**ANGEL PLACE
LEVEL 8, 123 PITT STREET
SYDNEY NSW 2000**

SSDA 8865 MOD 1- RESPONSE TO REQUEST FOR FURTHER INFORMATION

This letter has been prepared by Urbis Pty Ltd on behalf of Sydney Catholic Schools (SCS) in respect of the Section 4.55(2) application to modify the State Significant Development Application (SSD-8865) for concept approval and the staged construction of the St Anthony of Padua Catholic College at 125-165 Tenth Avenue and 140-170 Eleventh Avenue, Austral NSW 2179 (the project).

Drawing
CAR + BICYCLE PARKING PLAN

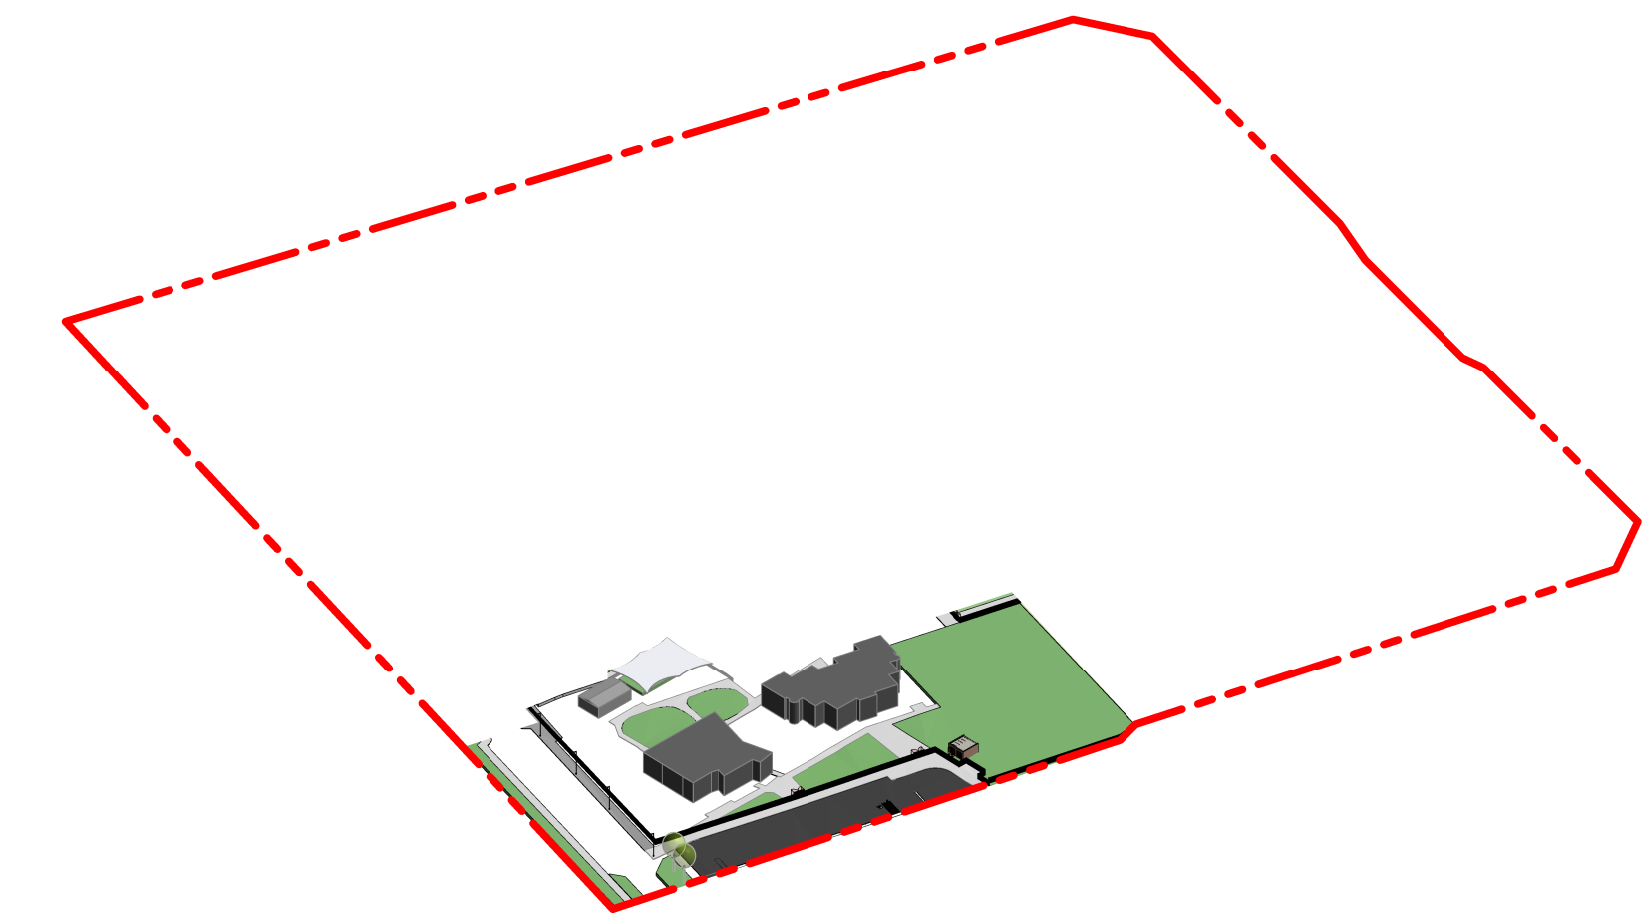
Issue	RFI comment	Response
	previously existing at the site, this does not explain why the number of 'existing' spaces outlined within the modification application are lower than those previously identified. Please clarify the difference. For example, have some of the previously identified spaces since been removed? Should this be the case, you will need to explicitly advise that this aspect of the development is subject to a retrospective modification request (see Point 2).	Council under DA 2016/465. This carpark was renovated as part of approved construction phase 1 which resulted in the loss of spaces to accommodate a generator, provide more space at the school entrance, and to avoid driveways.

Car spaces	Accessible	Drop off	Comment
Carpark 1				
SSDA 8865	31	2	0	3 parallel car spaces removed to avoid locating spaces opposite driveways or at the entrance of the school on Eleventh Avenue. 1 standard car space removed to provide more space to driveways. 1 accessible carpark removed for substation.
Proposed modification	27	1	0	Four standard spaces removed from this carpark have been provided in Carpark 4. The accessible space removed from this carpark has been provided in Carpark 3.
Carpark 2				
SSDA approval	101	4	24	No change.
Proposed Modification	101	4	24	
Carpark 3				
SSDA approval	31	2	0	2 additional accessible spaces provided. 1 drop off space provided.

Car spaces	Accessible	Drop off	Comment
				Four standard spaces removed from this carpark have been provided in Carpark 4.
Proposed Modification	27	4	1	
Carpark 4				
SSDA approval	112	4	36	Eight additional standard spaces provided in this carpark to compensate for those removed from Carpark 1 and Carpark 3.
Proposed Modification	120	4	35	
Carpark 5				
SSDA approval	37	2	65	1 accessible space removed from this carpark and provided instead in Carpark 3.
Proposed Modification	37	1	65	
Total				
SSDA 8865	312	14	125	No change to the total number of spaces to be provided.
Proposed Modification	312	14	125

1 MASTERPLAN - PHASE 2
A3000 1 : 1000

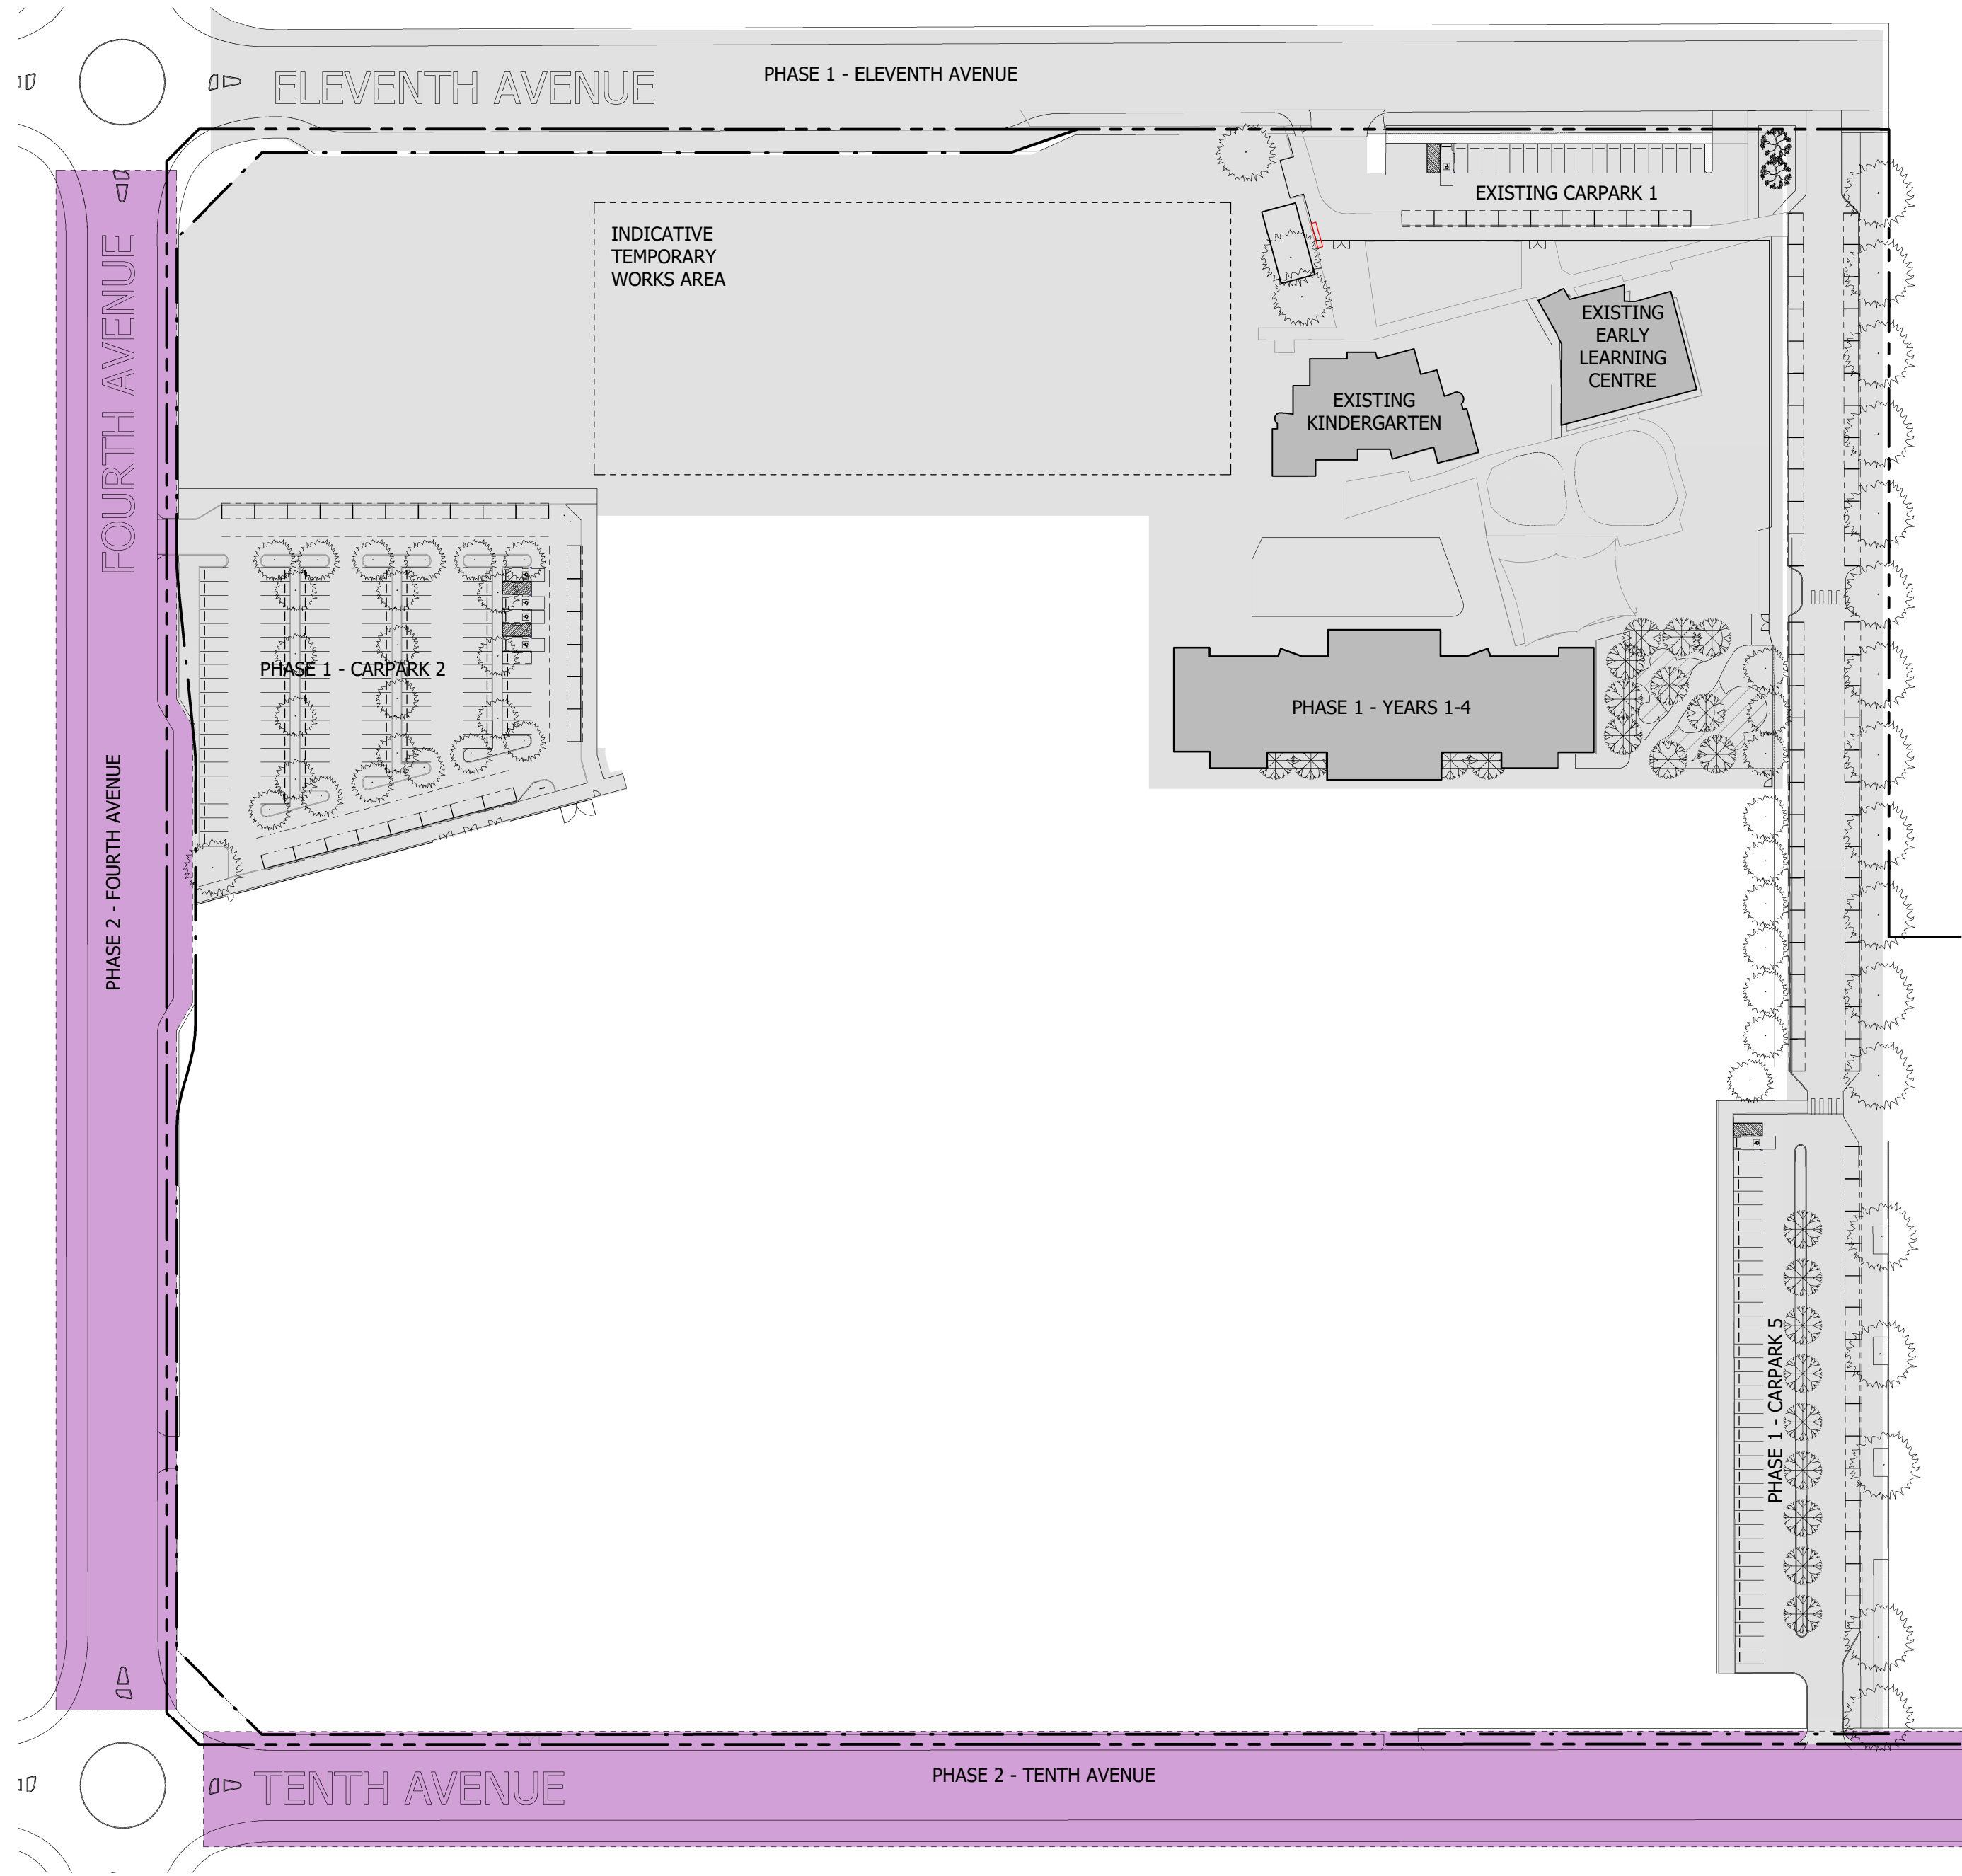
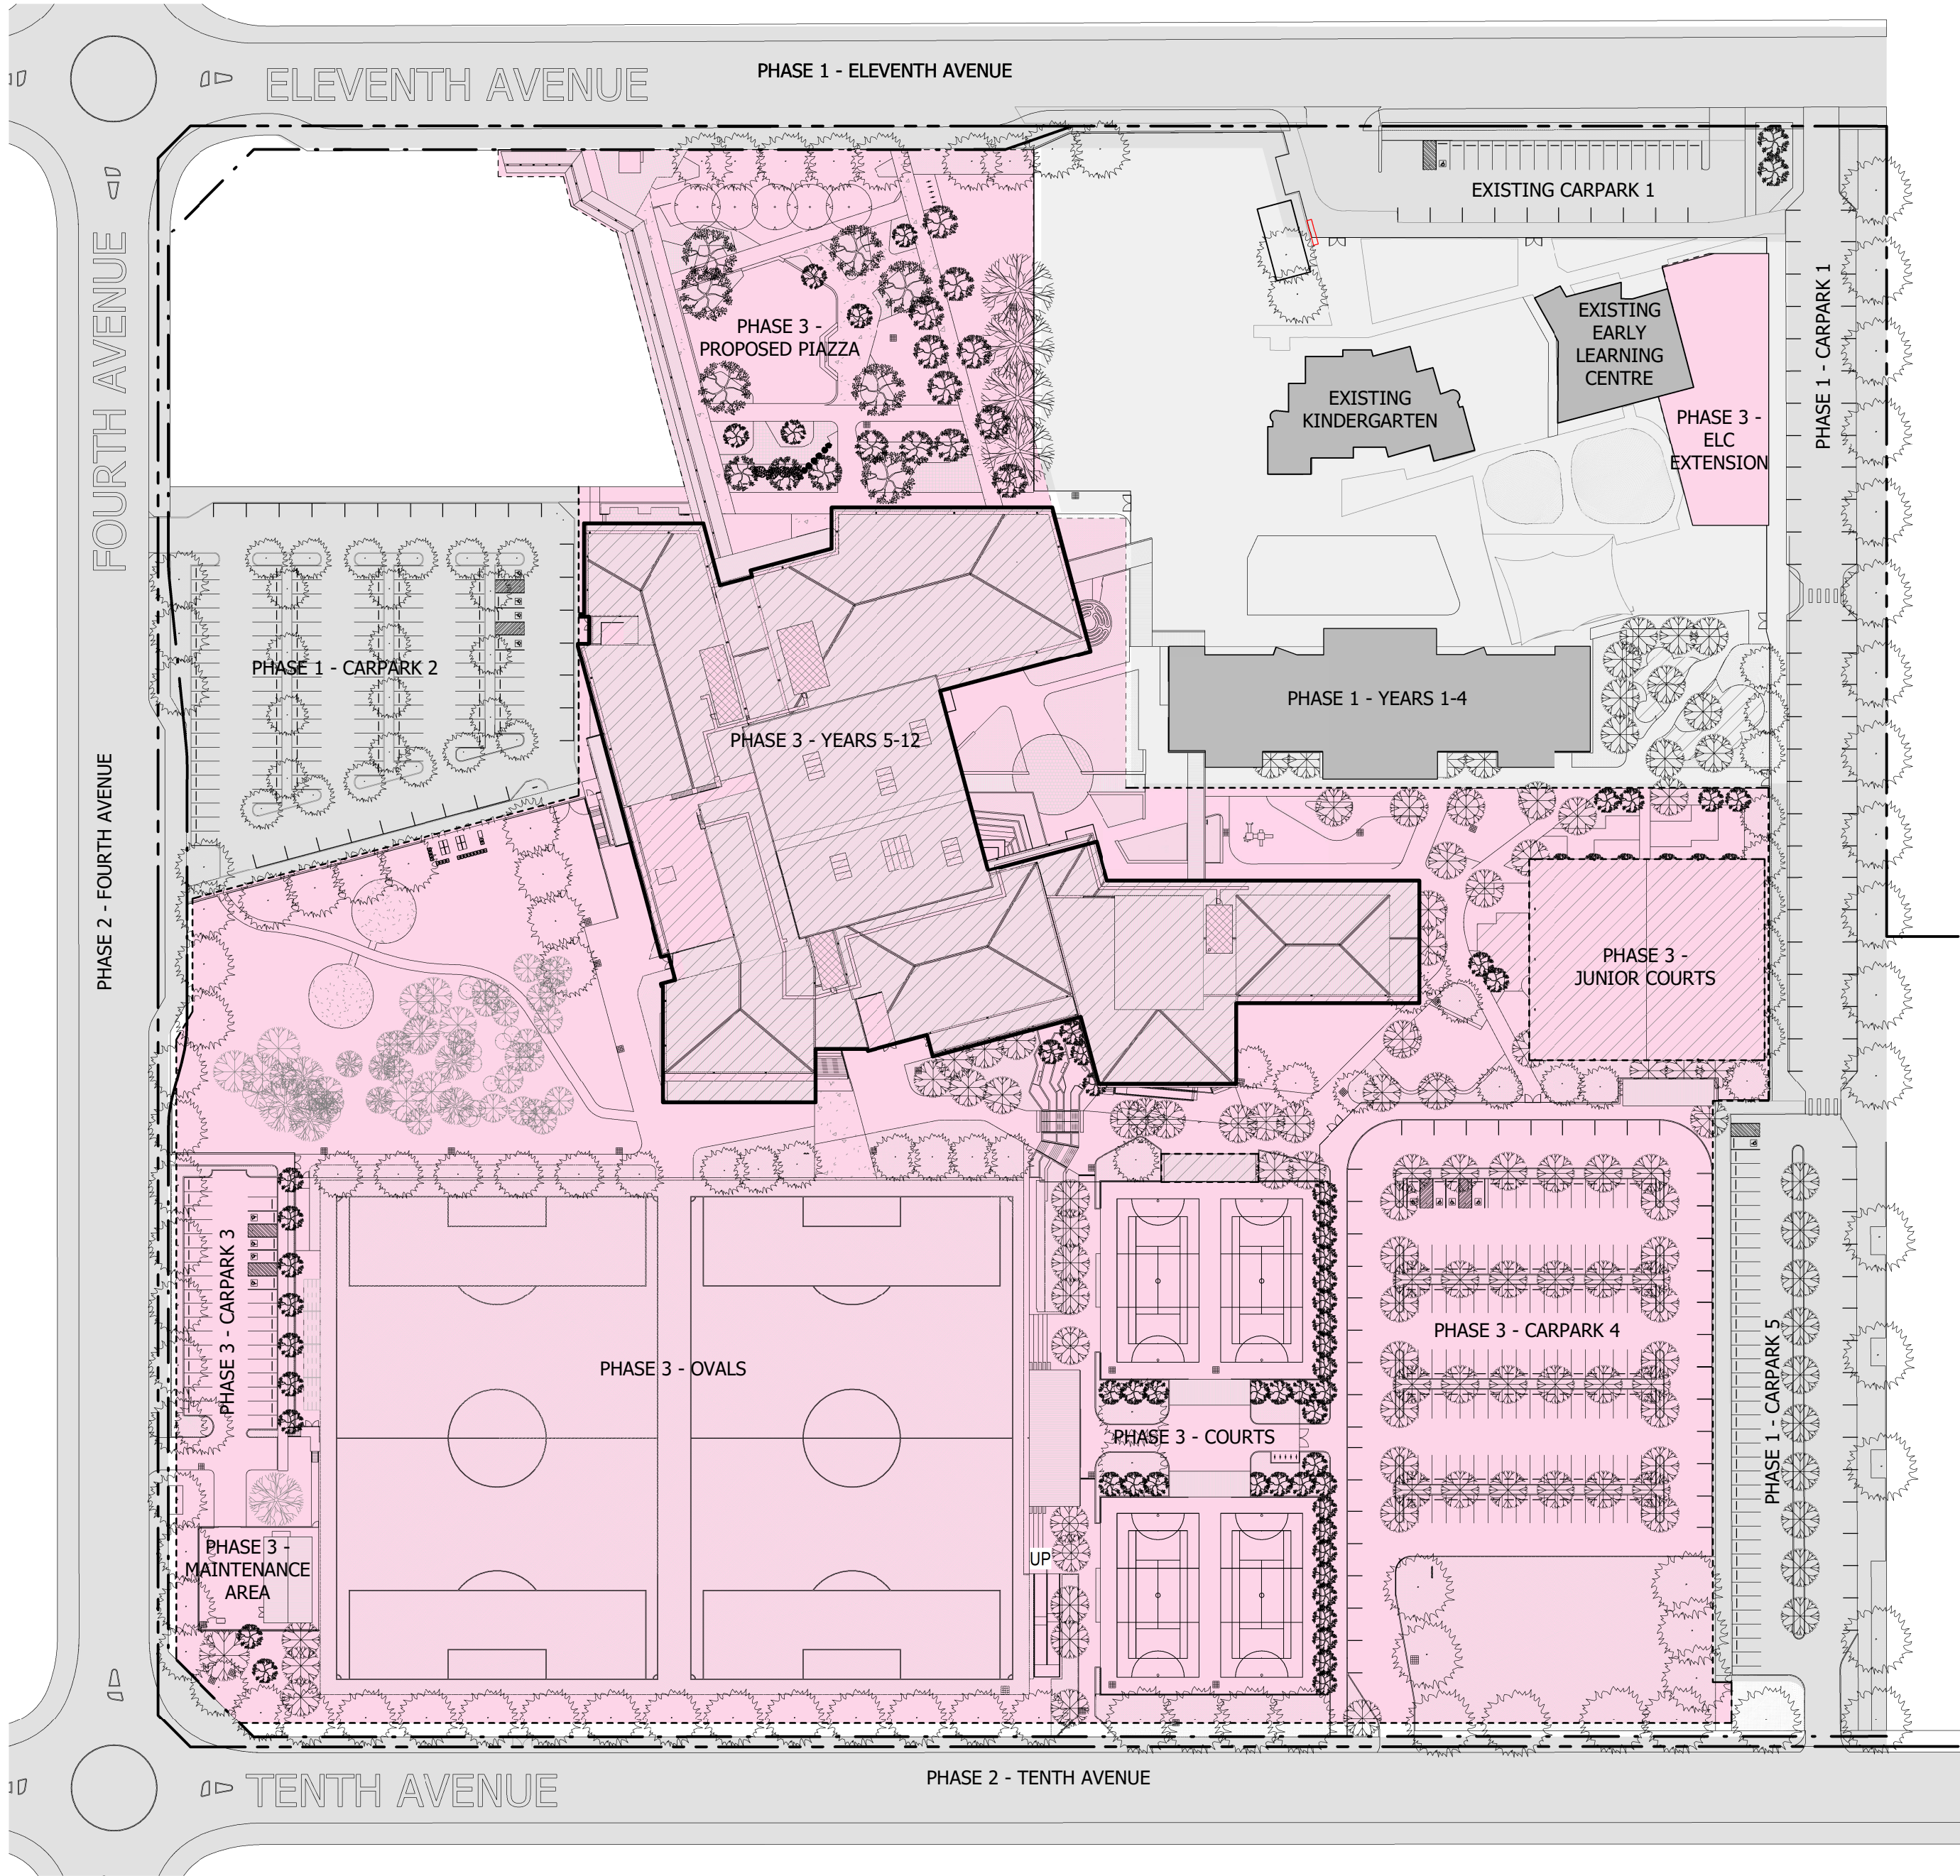
4. Provide amended architectural drawings to demonstrate the proposed bus shelter.	Updated Concept Approval site plans and construction phasing plans showing the location of the proposed bus shelter are included at Attachment A .

The proposed bus shelter is now shown on the Concept Approval site layout and is identified as part of Construction Phase 3.
